PR-2022-007589; PS-2022-00260 (DRB sketch plat 12/7/22); PS-2022-00194 (sketch plat at DRB); PR-2018-001681 per planning sketch plan comments

January 12, 2023

**Re: Sketch Plat Review for Proposed Parcels B-1 and C-1-A, Tijeras Place Addition,
located at 300 San Mateo Blvd NE and 5300 Copper Ave NE**

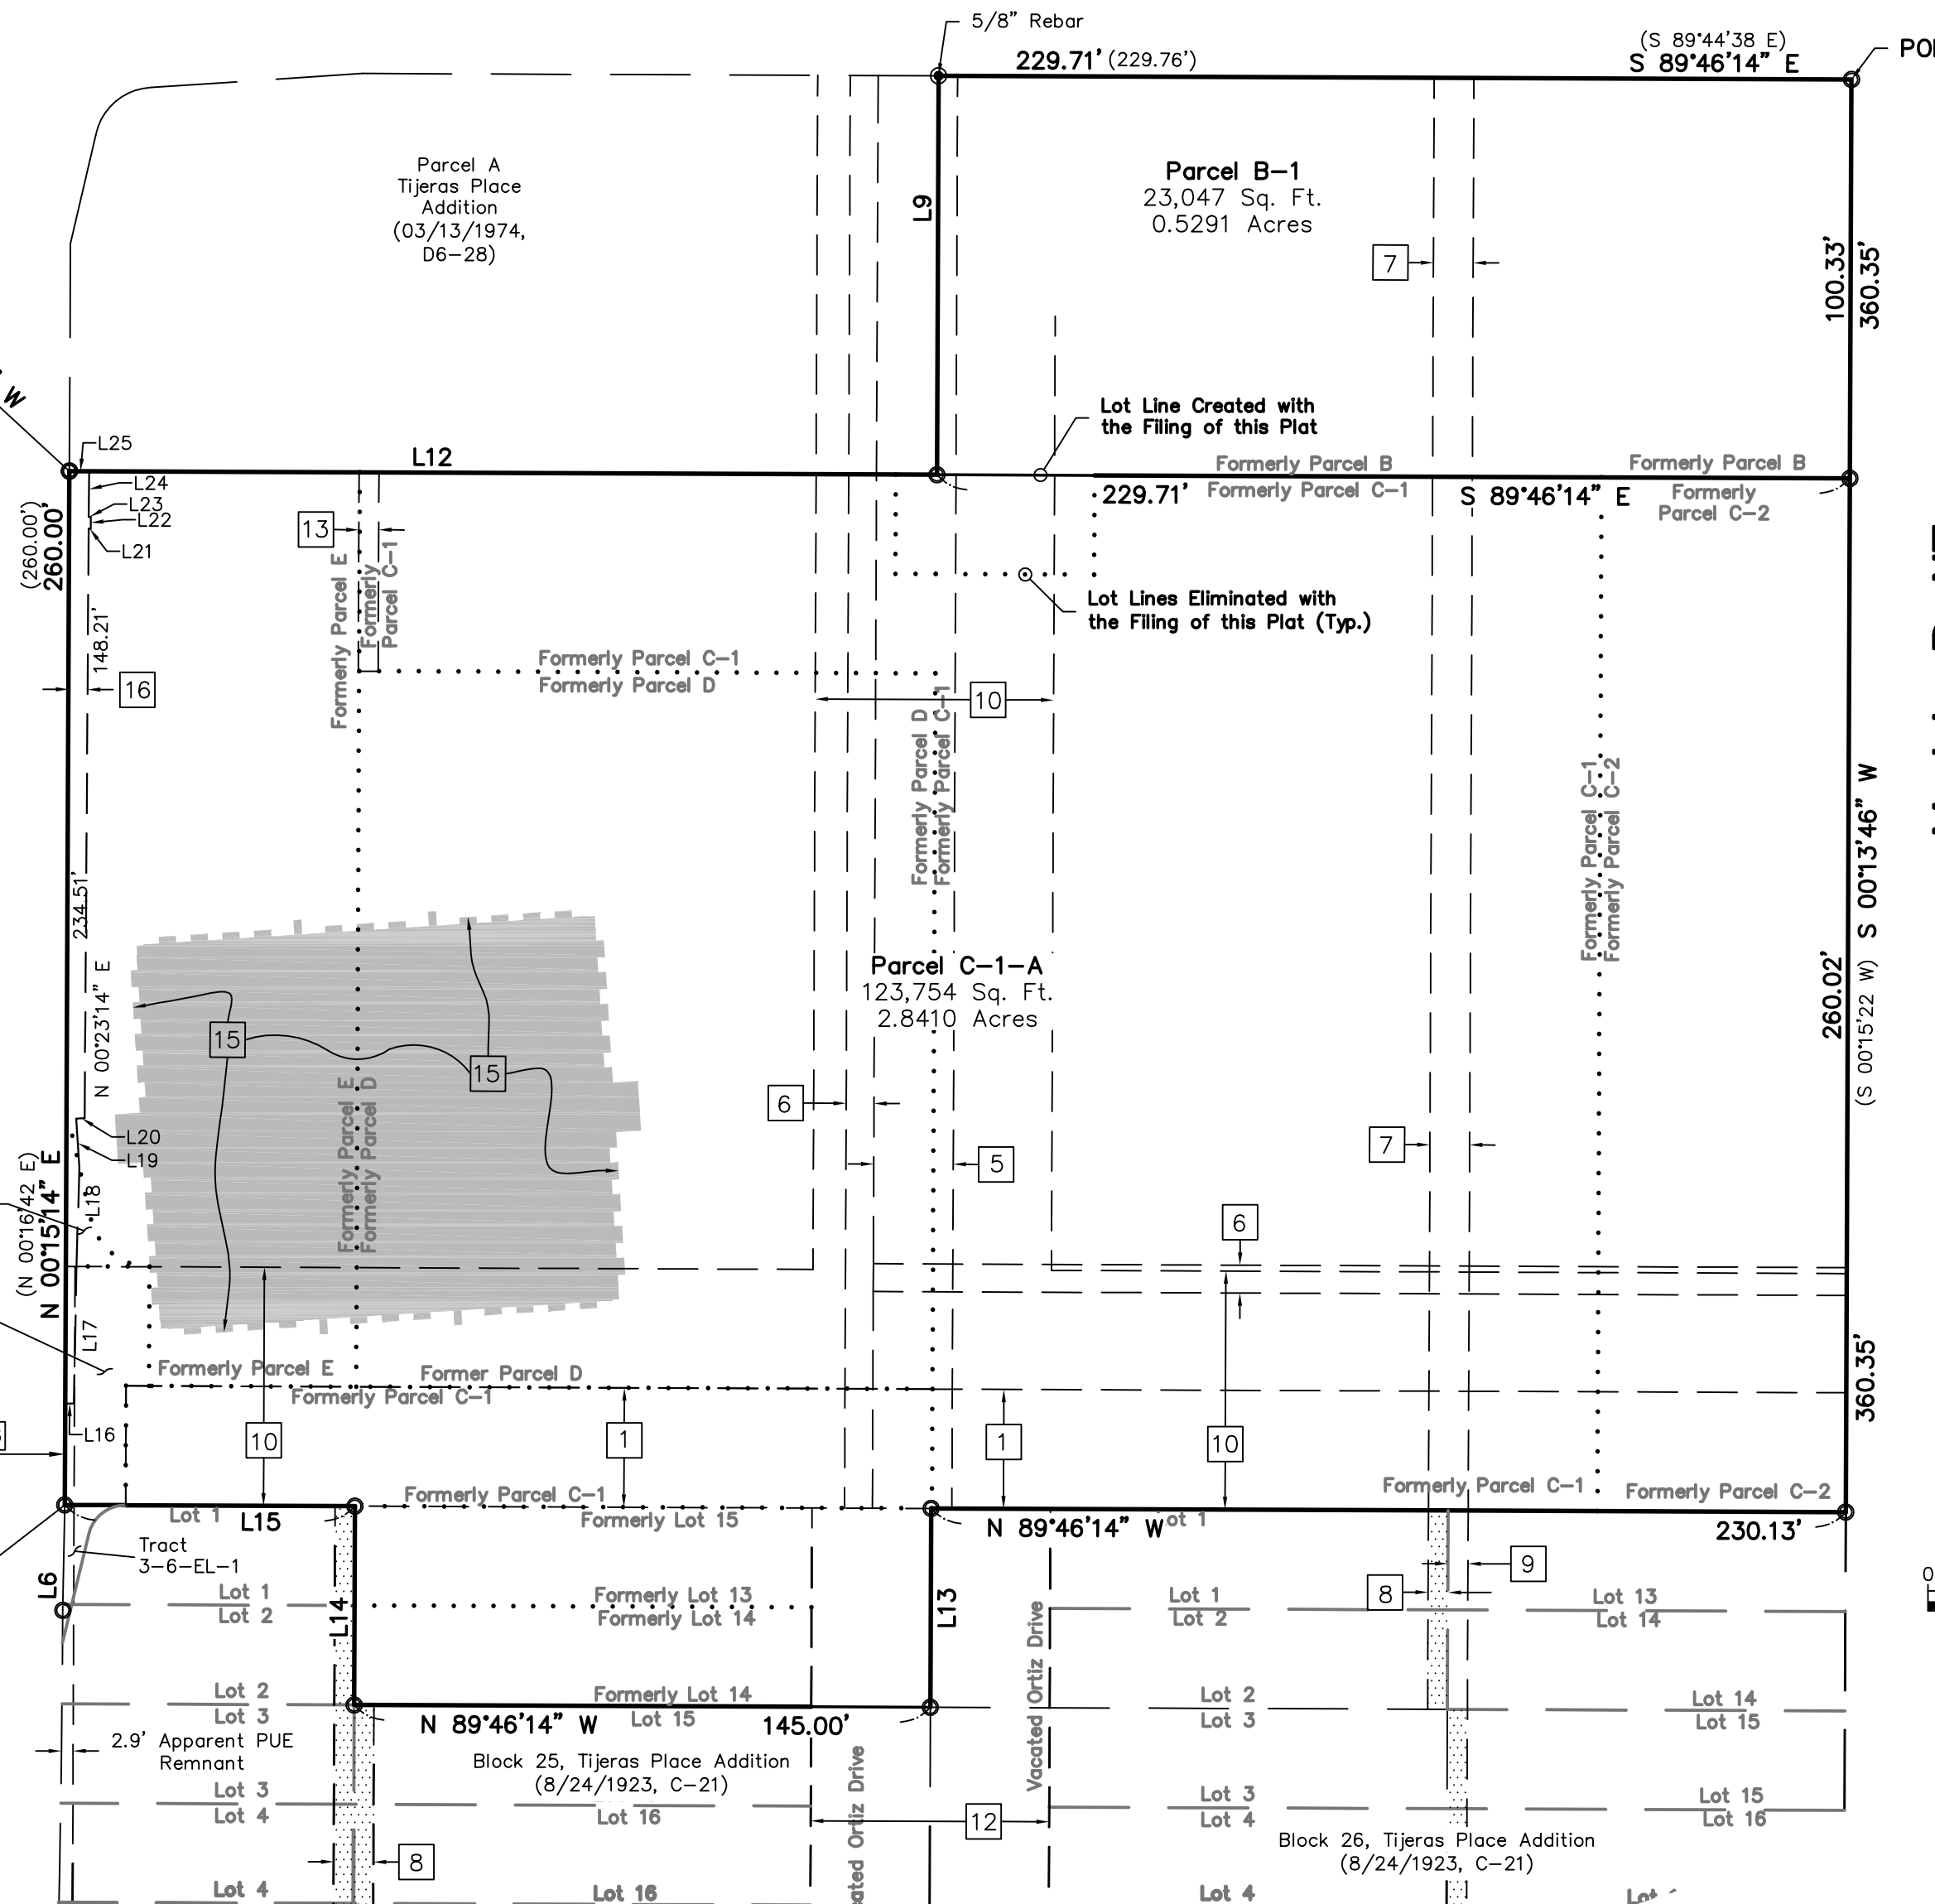
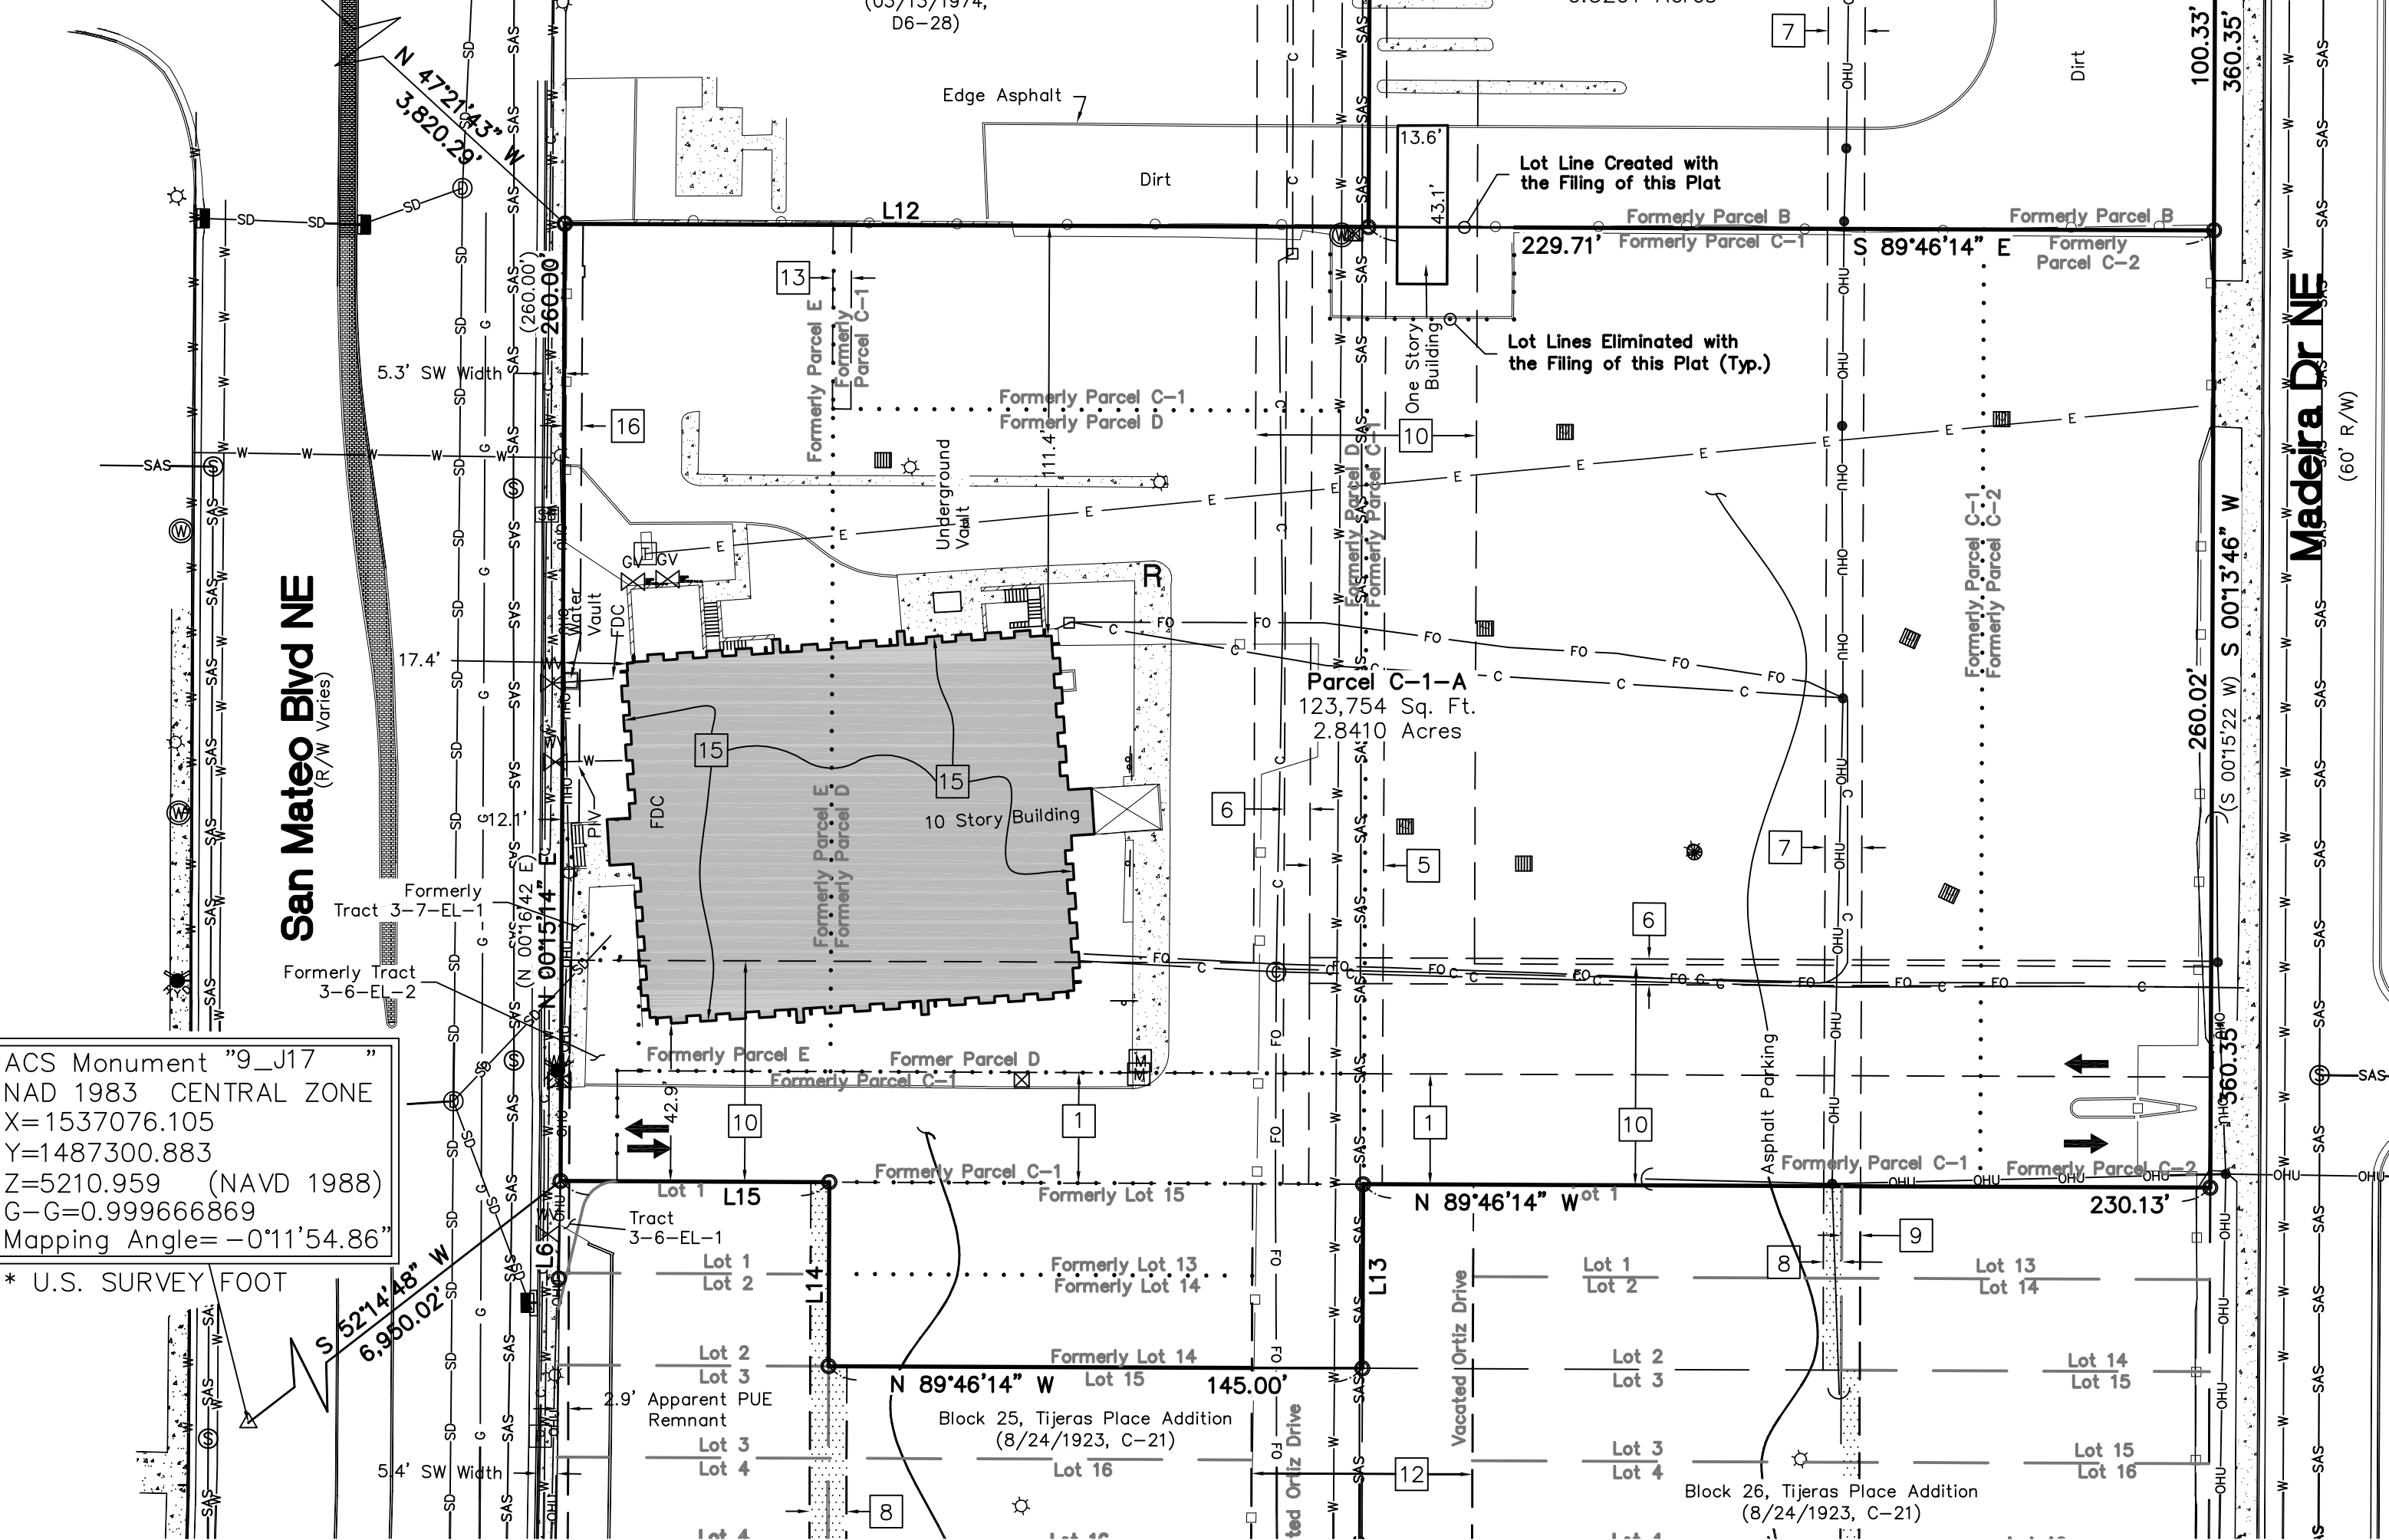
1. Proposed re-plat is correctly drawn along Zoning lines, to avoid mixing two zones, MX-M and MX-L. Proposed properties must meet Dimensional standards for the MX-L and MX-M zones respectively, as per IDO section 5-4(C) Compliance with Zoning Requirements.
2. Building crosses lot lines. This action shows a one-story building that is dissected by the newly proposed lot lines for parcel B-1 and parcel C-1-A, which is not in compliance with the IDO Dimensional Standards for setback requirements, as per IDO section 5-1(C), Table 5-1-2.

3. Parking for business located on proposed parcel B-1 appears to be located on parcel C-1-A (the same structure as noted above). Please clarify if this business is going to remain and, if so, what arrangements will be made to preserve required parking. Reference IDO section cited below:

Building is intended to be removed with proposed subdivision consolidating lots, and footpath leading to Parcel C-1-A created in place.

Parking for Parcel B-1 will be for use of Parcel C-1-A site, and so cross-lot parking and access easement 18 is proposed with our plat. Cross lot parking and access to the lots south of this one is not desired for future use, and is not necessary for future development plans.

A3 DRB SITE PLAN  
1" = 50'-0"

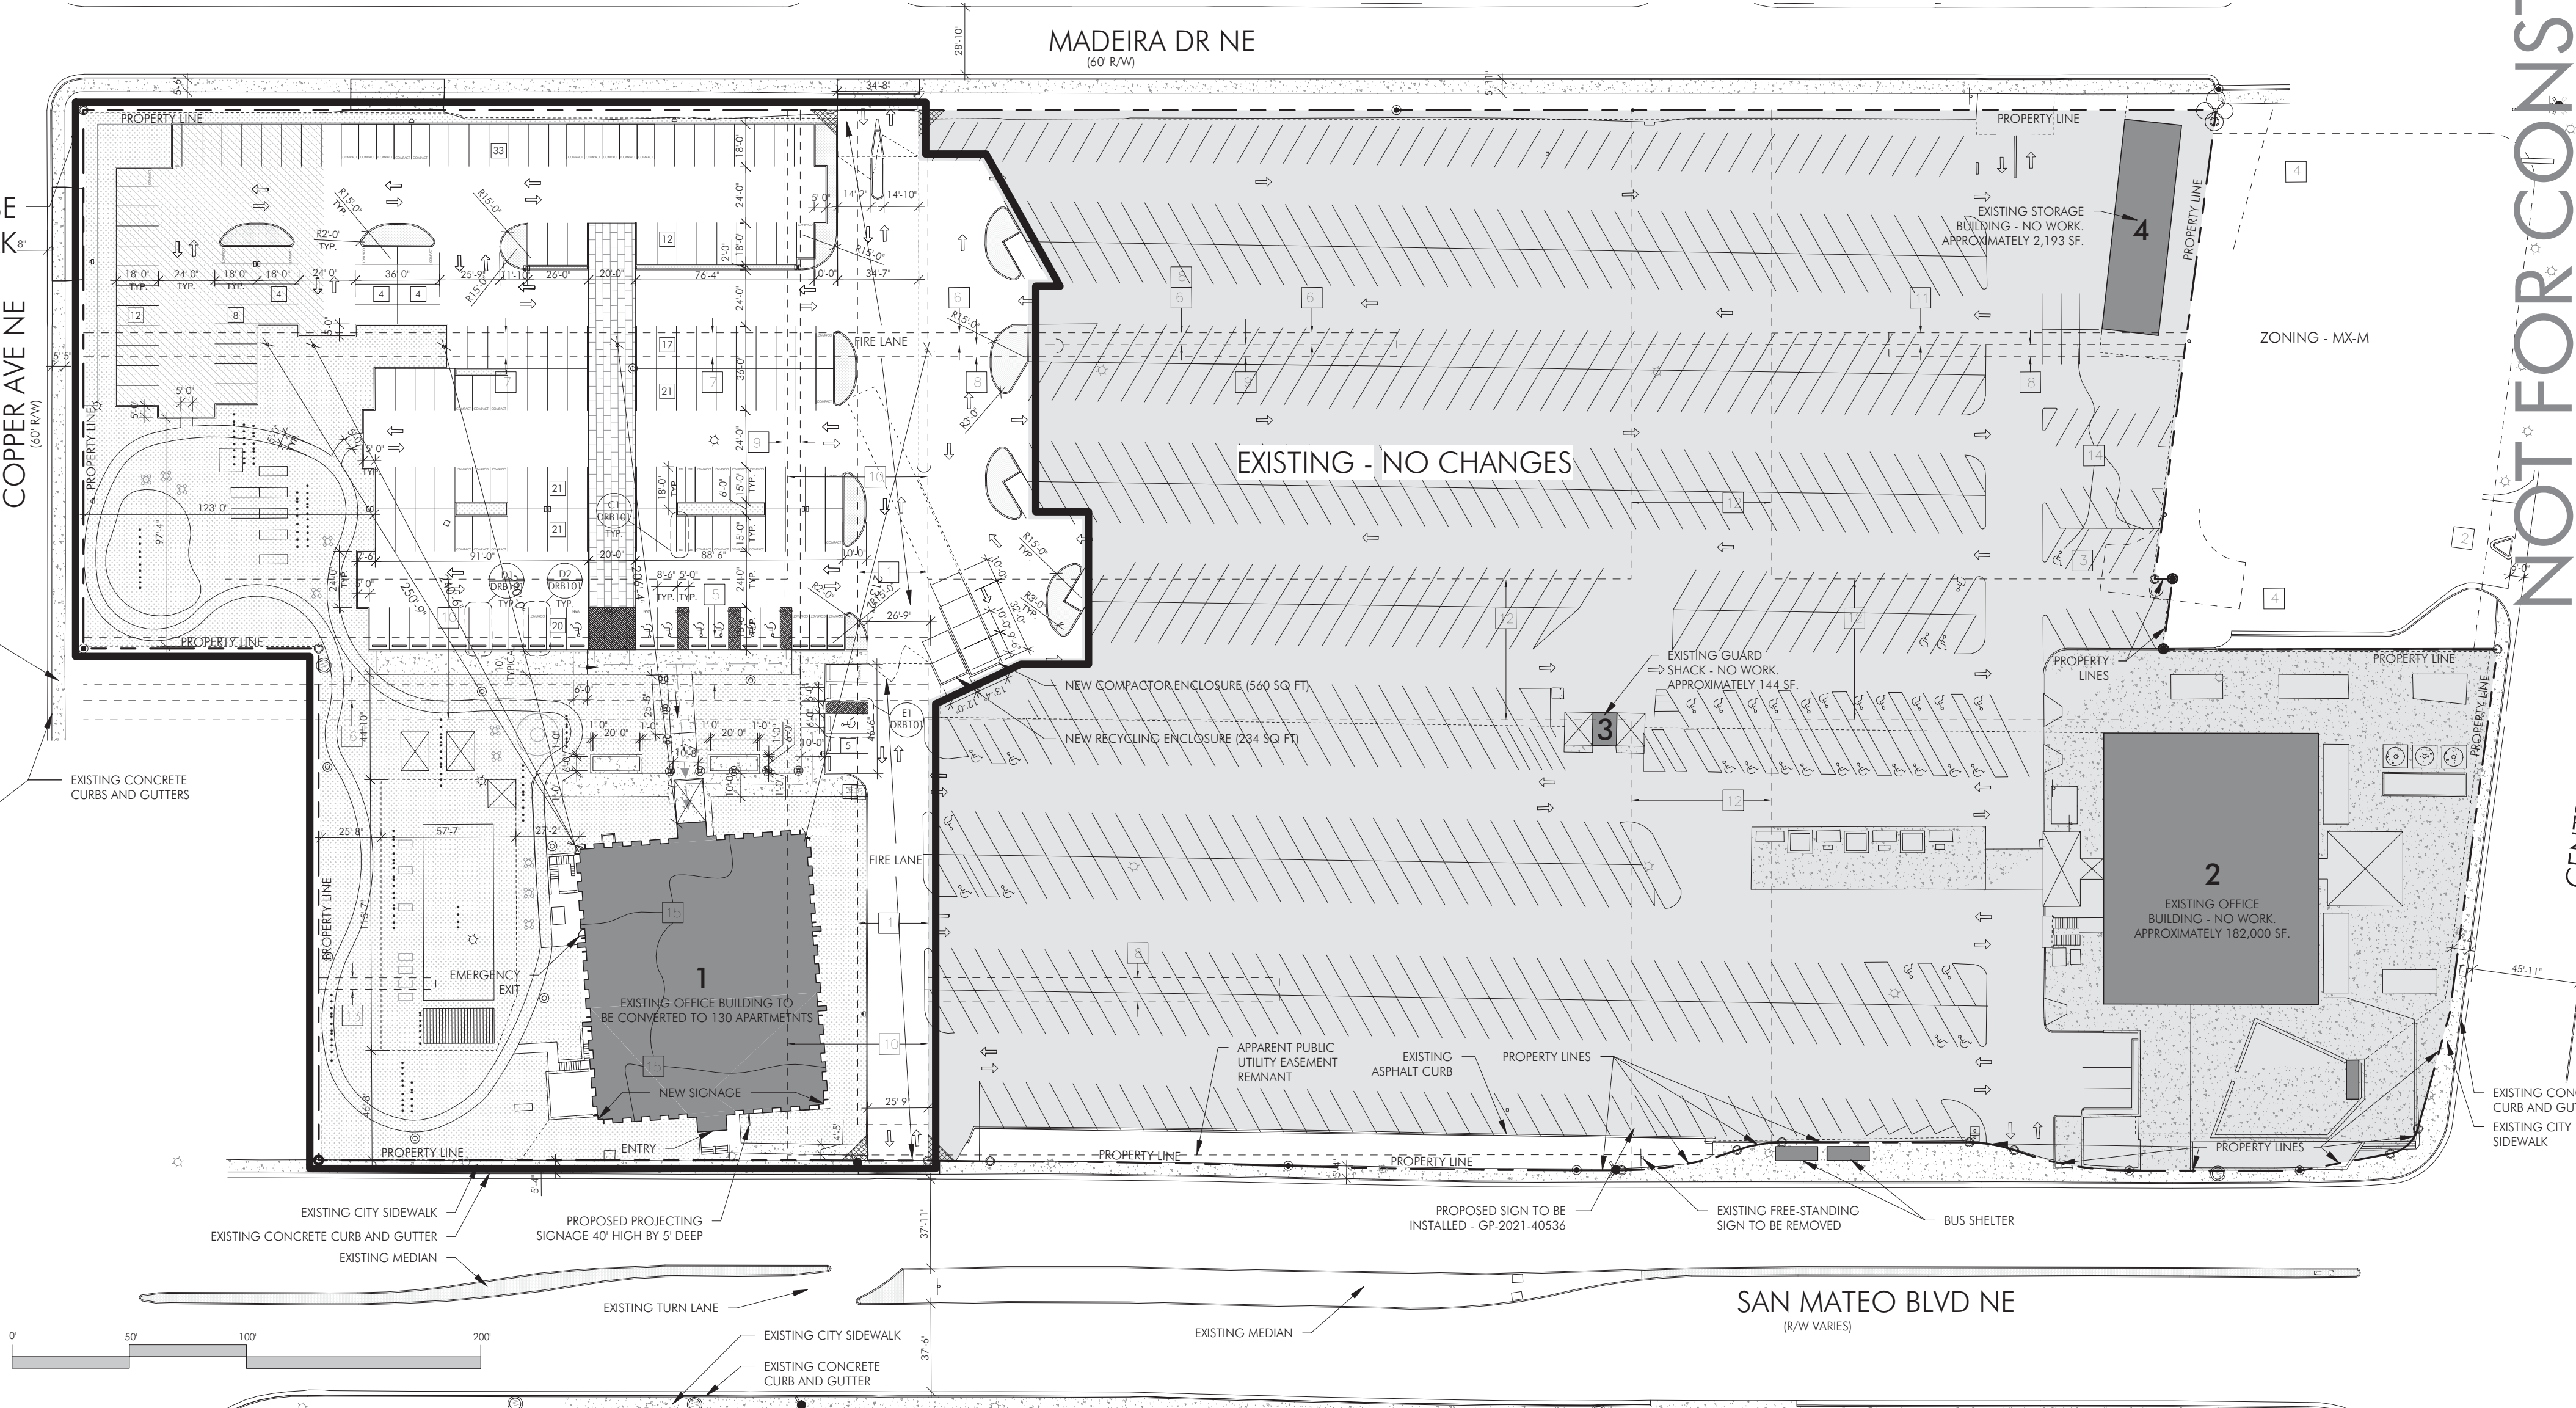
***Clarify proposed development and proposed uses.**

***Clarify existing structures and any proposed demo.**

Noted, proposed development will retain use of town for residential purposes and proposed parcel B-1 will have amenities for the residences (path around playground, community garden, remainder is parking). Minor accessory building straddling the
